Our Ref: EN010095

Date: 20 April 2021

### **Application by Alternative Use Boston Projects for an Order Granting Development Consent for the Boston Alternative Energy Facility**

#### **Advice following issue of decision to accept the application for examination**

TITLE
**BOSTON ALTERNATIVE ENERGY FACILITY
 DEVELOPMENT CONSENT ORDER
 Regulation 5(4) -
 Indicative Electrical and Water Connection Key Plan
 BOSTON BOROUGH COUNCIL
 SHEET 1 OF 1**

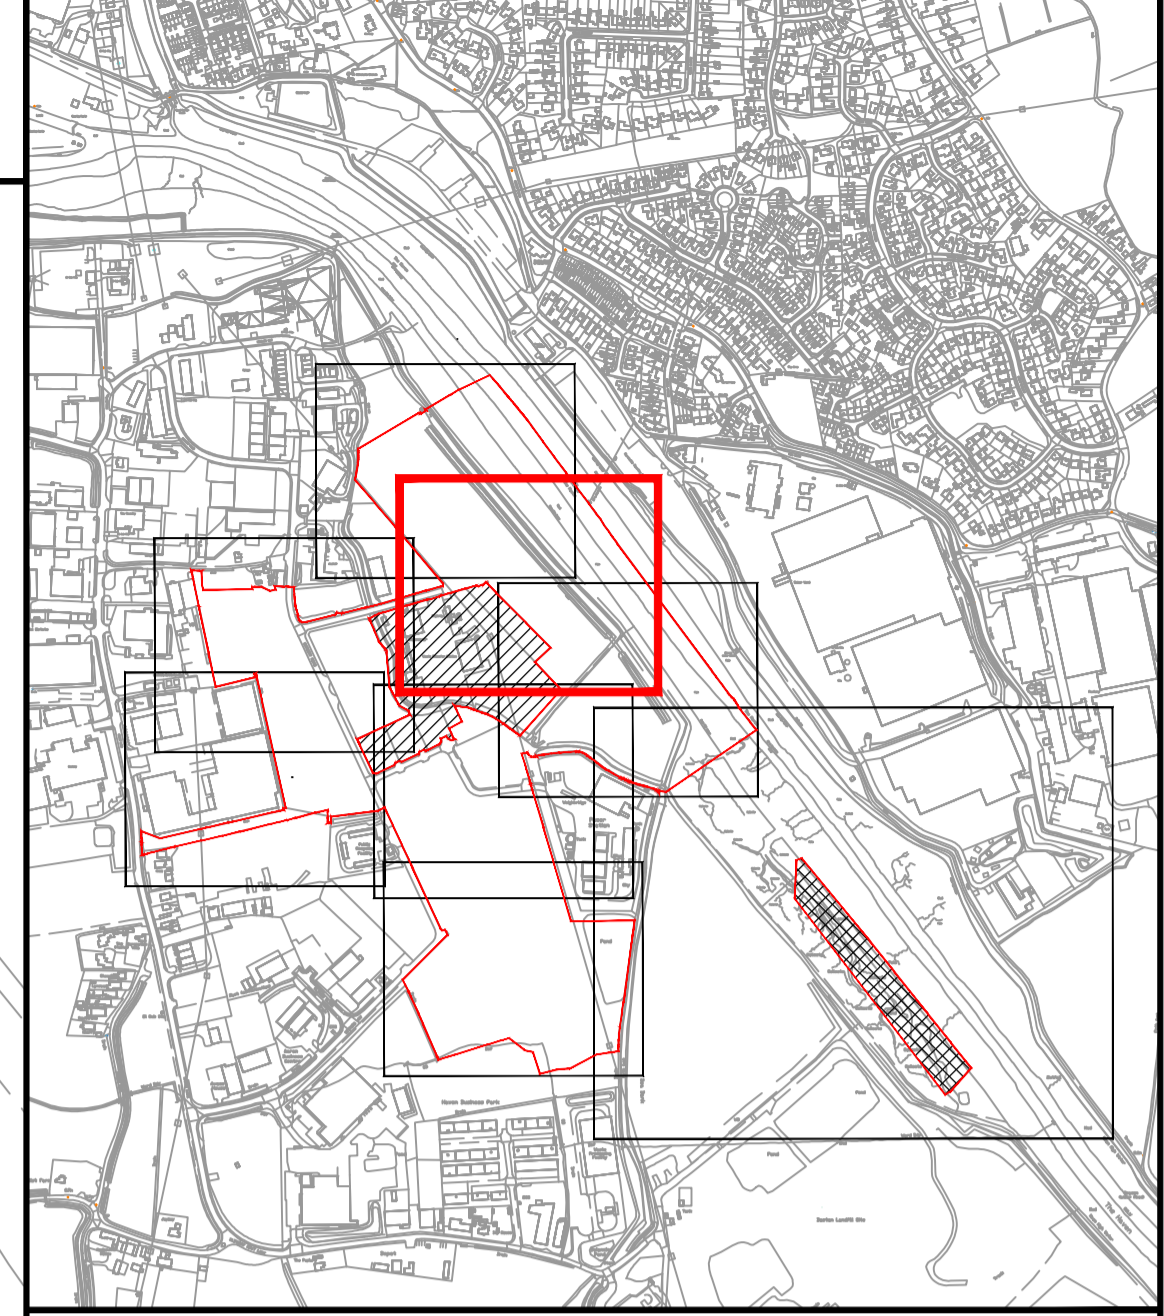
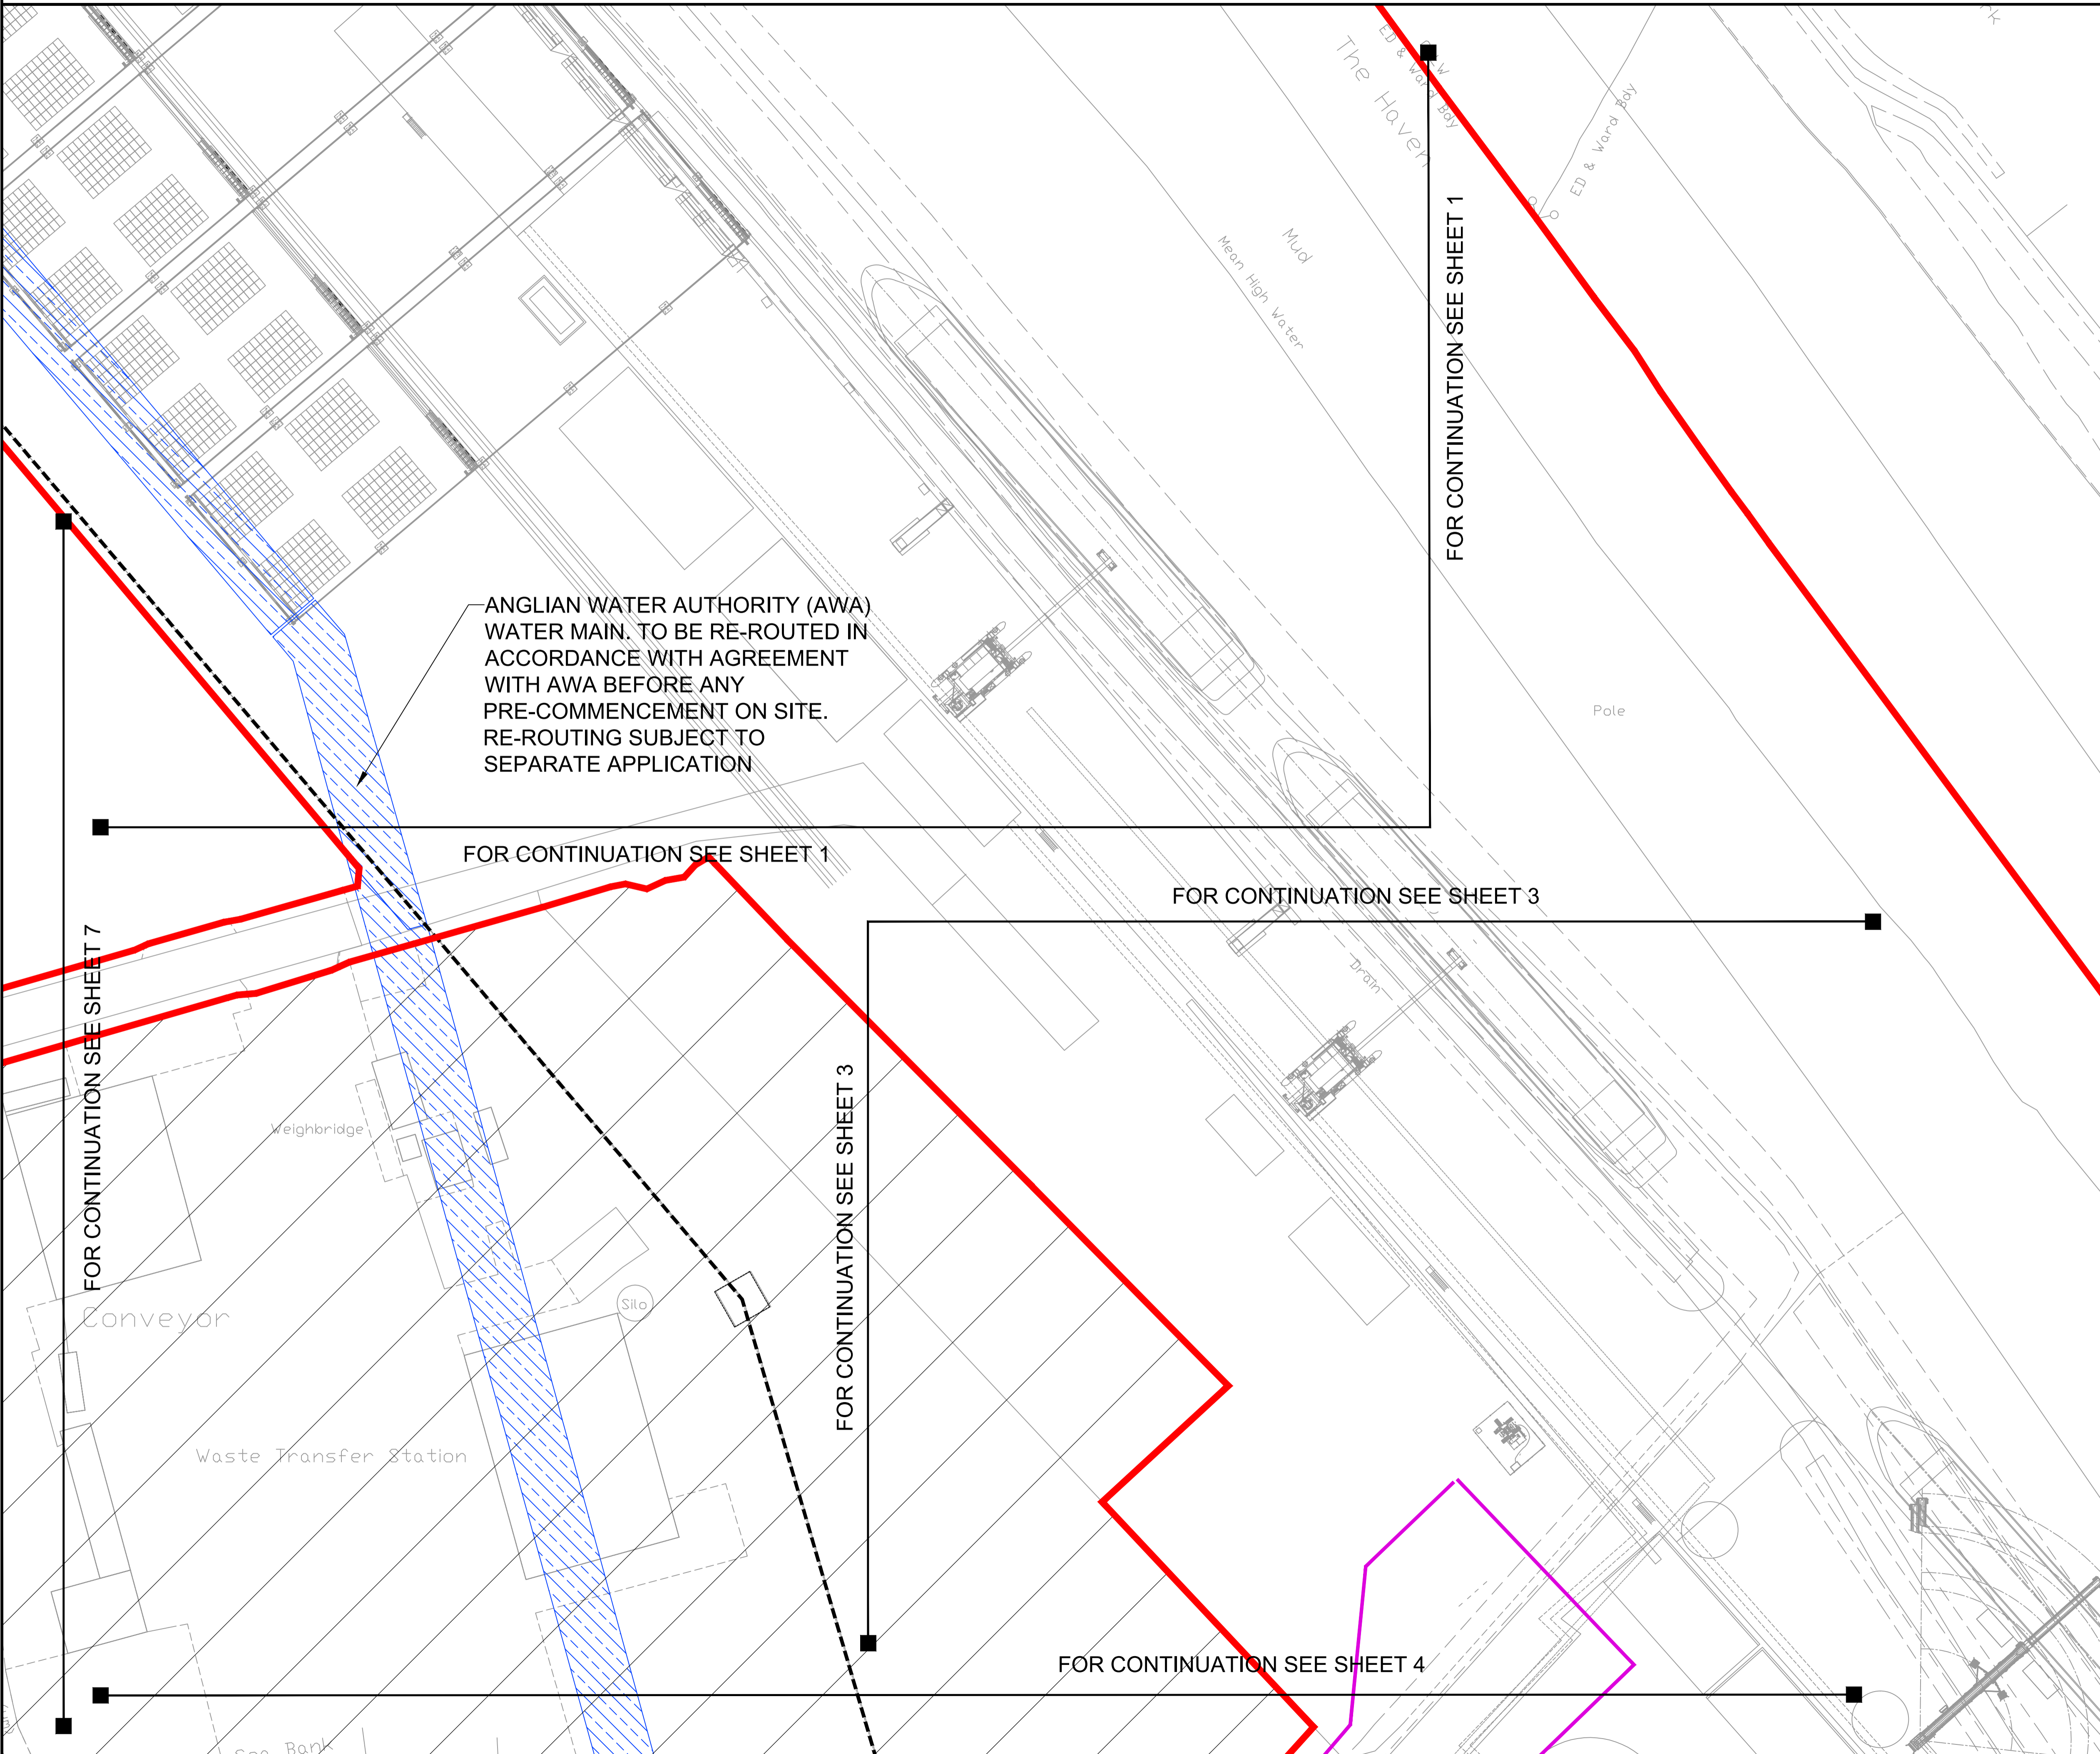
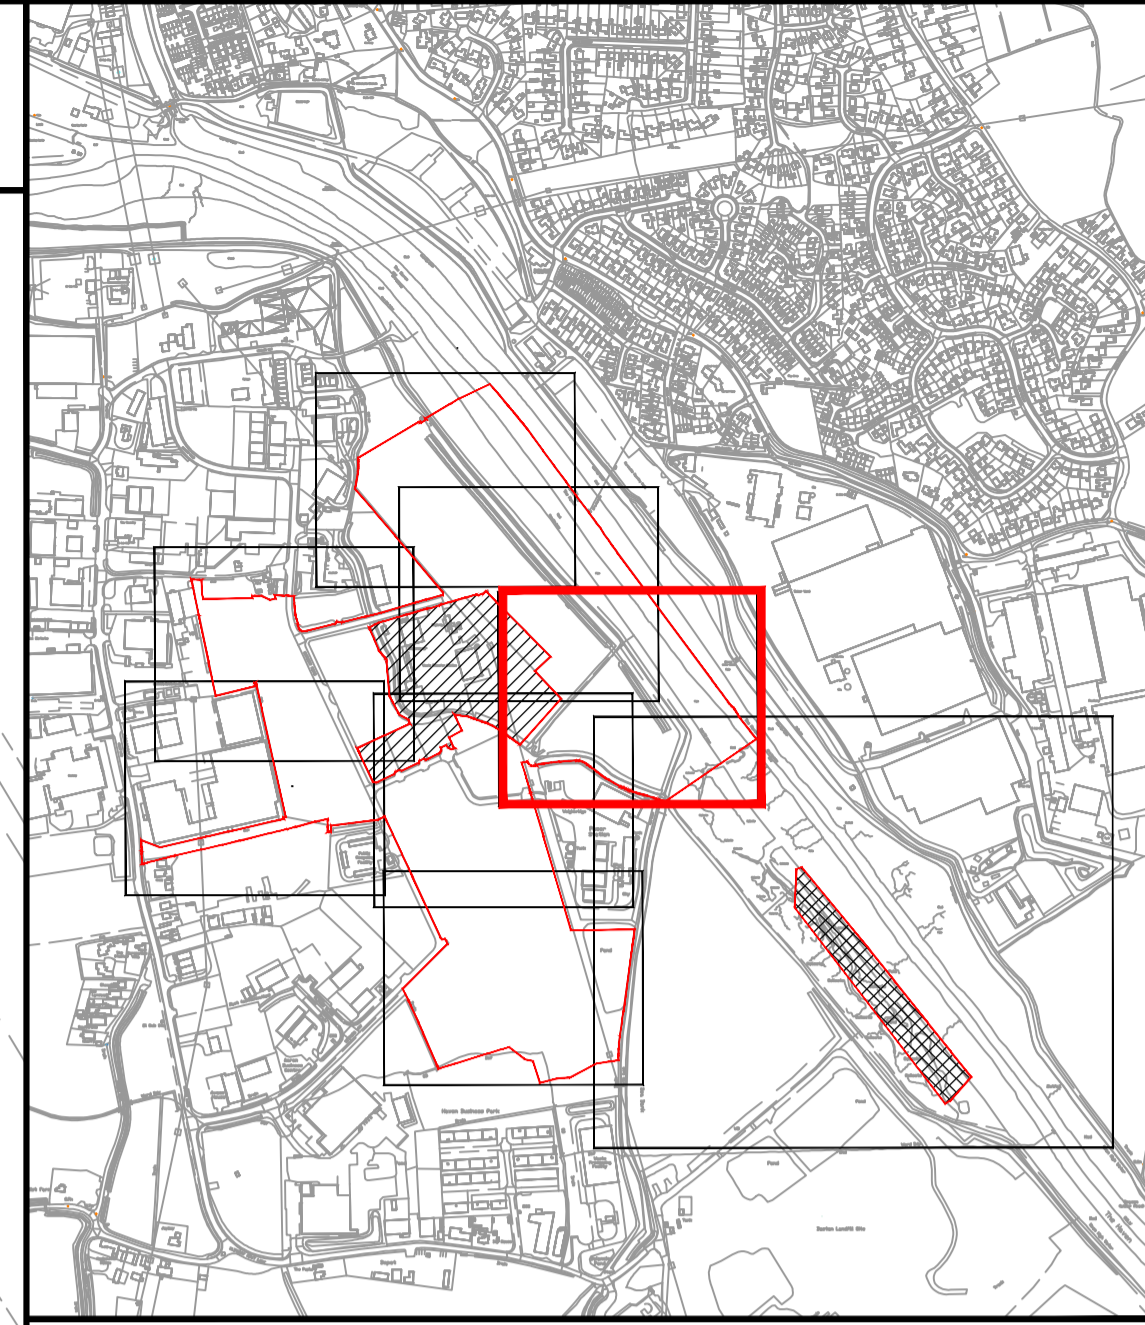
On the key plan 'SHEET 5 OF 7' should refer to 'SHEET 5 OF 8'.

The Applicant may wish to note the above and correct any errors when submitting updated documents in the Examination.
